PRELIMINARY/FINAL DRAINAGE REPORT FOR PINE VIEW ESTATES

JUNE 2020

SP-20-004

SF-20-019

DRAWN BY: MGP  
DATE: 11/11/20  
SHEET: 3

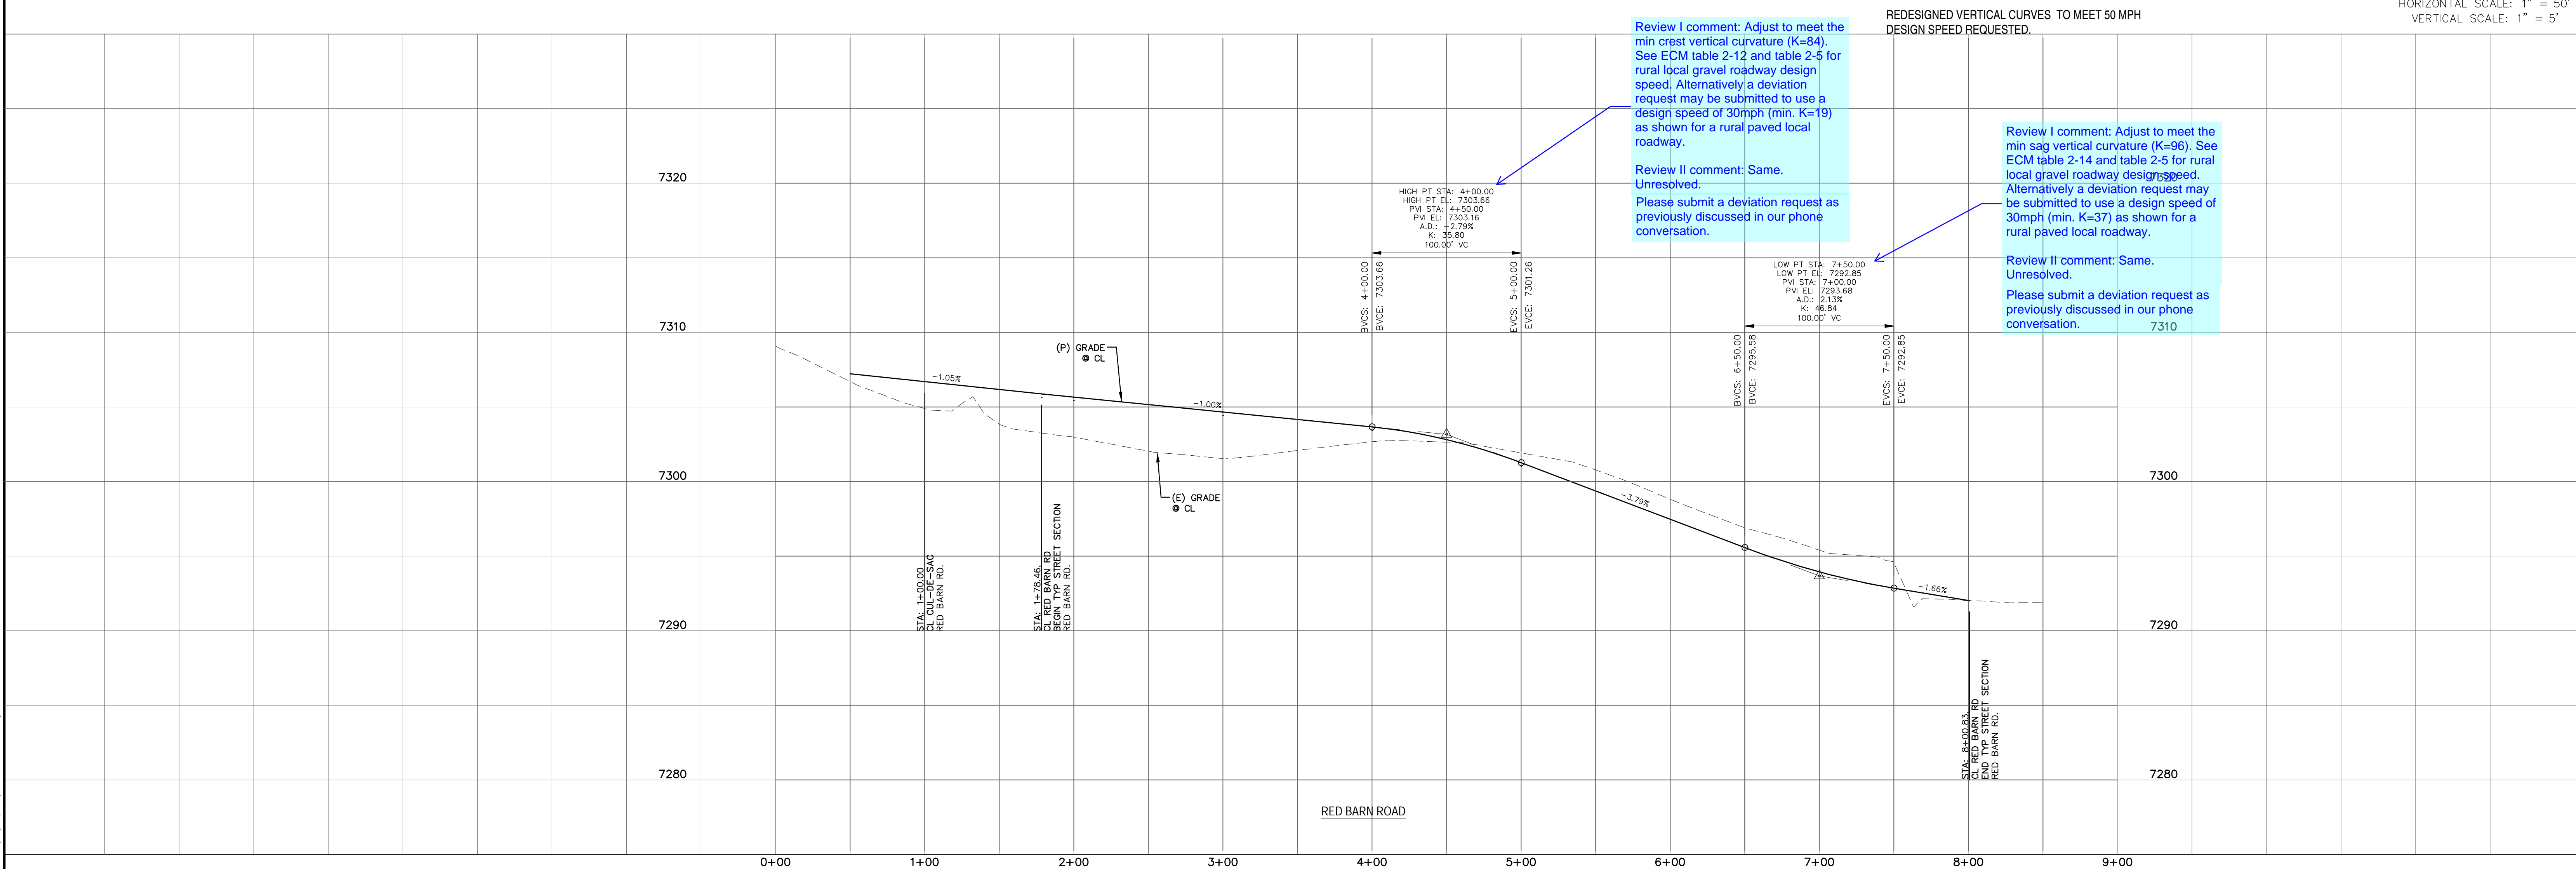
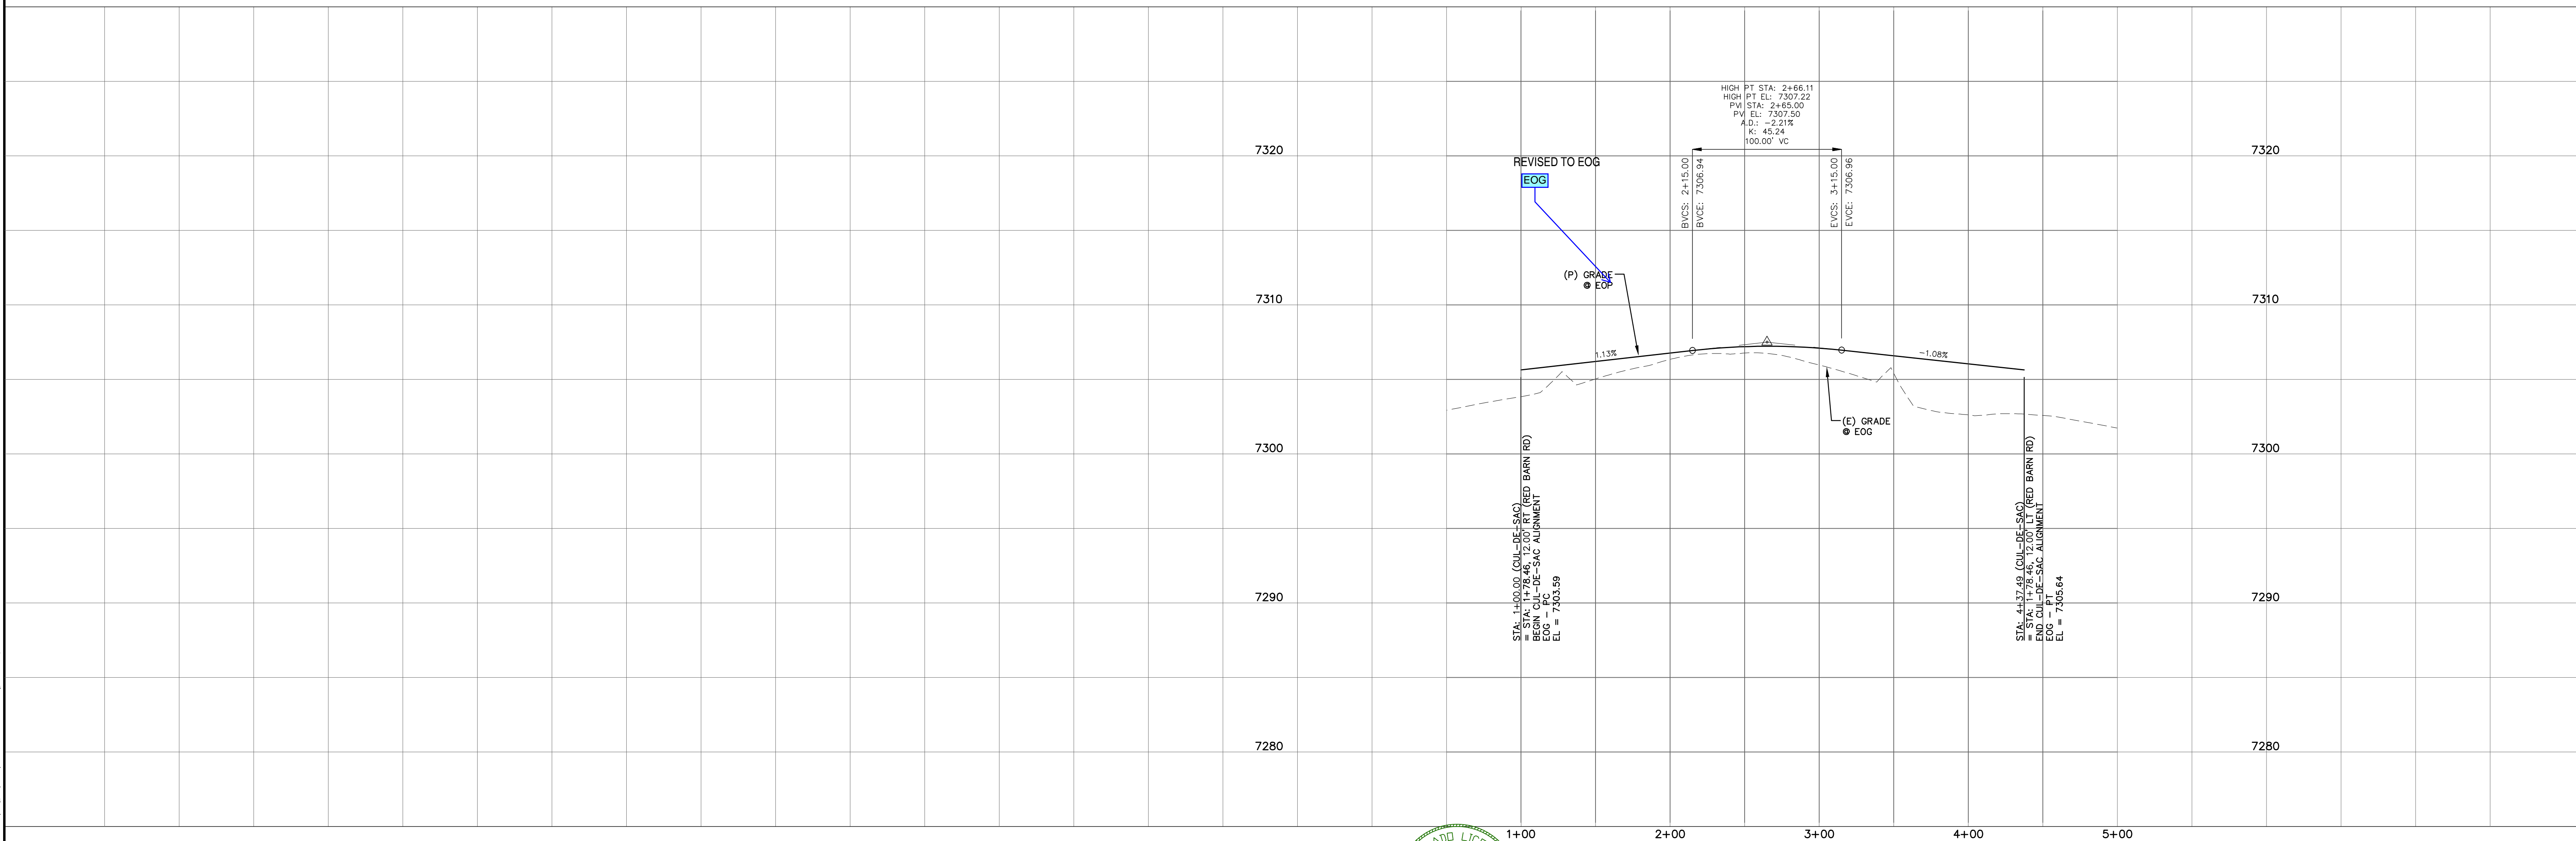
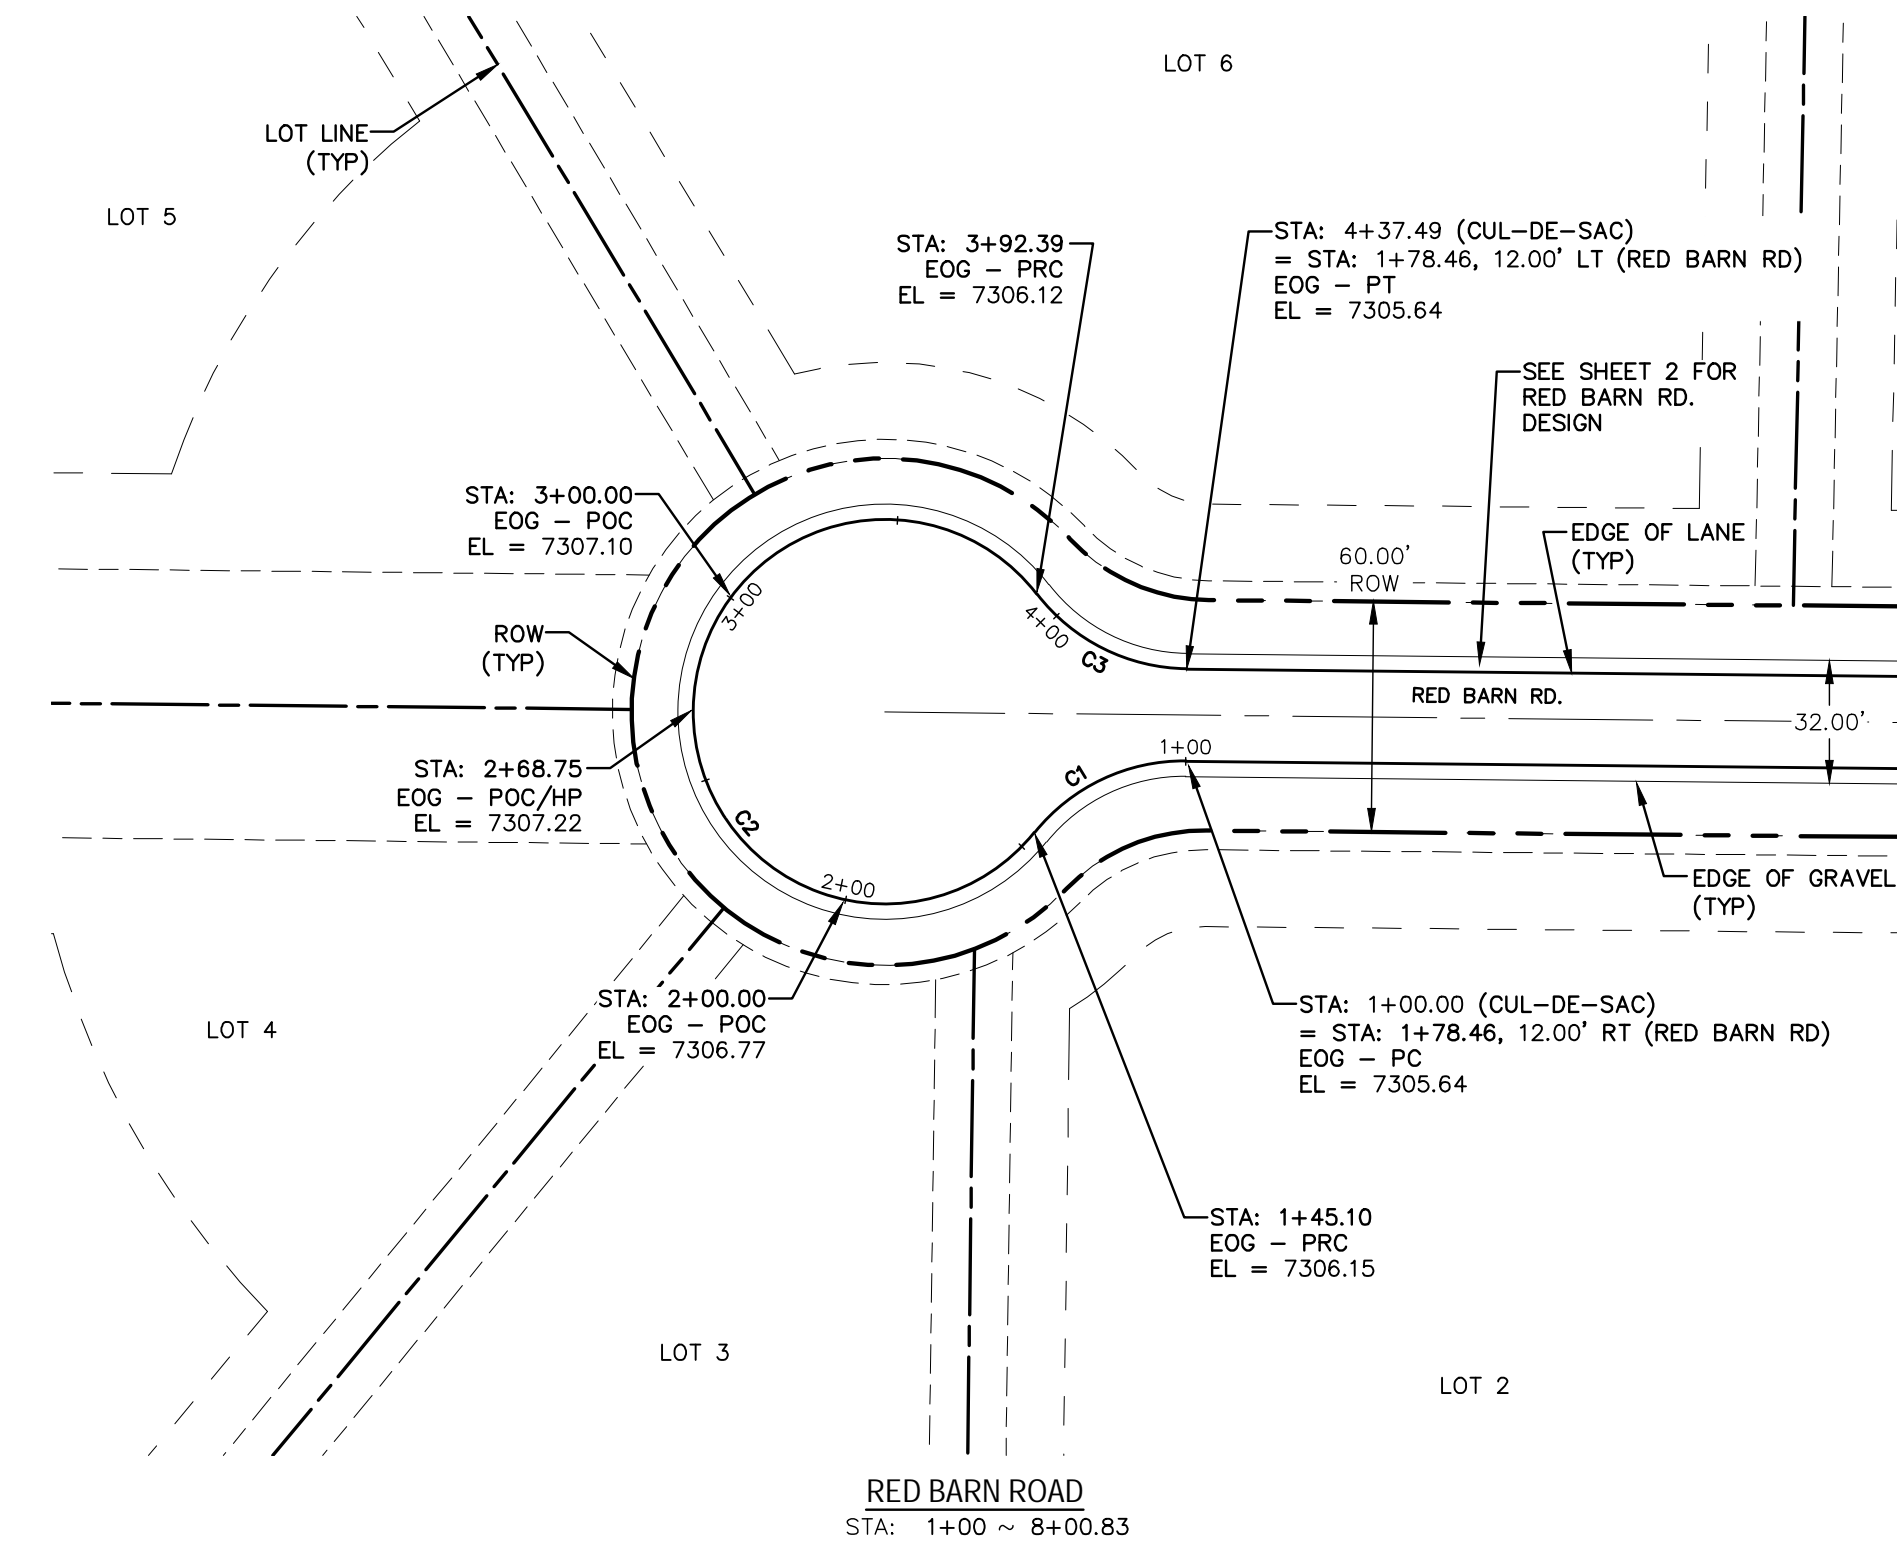
See comment on GEC Plan
Drawing in regards to the need
for a permanent WQ facility

per your drainage plan it appears to flow to the northwest. Please revise

northeasterly per the drainage plan

northwest

The northern half of the roadway will flow to the roadside ditch and flow easterly. Revise accordingly.

There is no mention of channel improvements in your narrative or shown on the drainage plan. Please revise.

There is no storm drains/gutters proposed on the plans. Please revise.
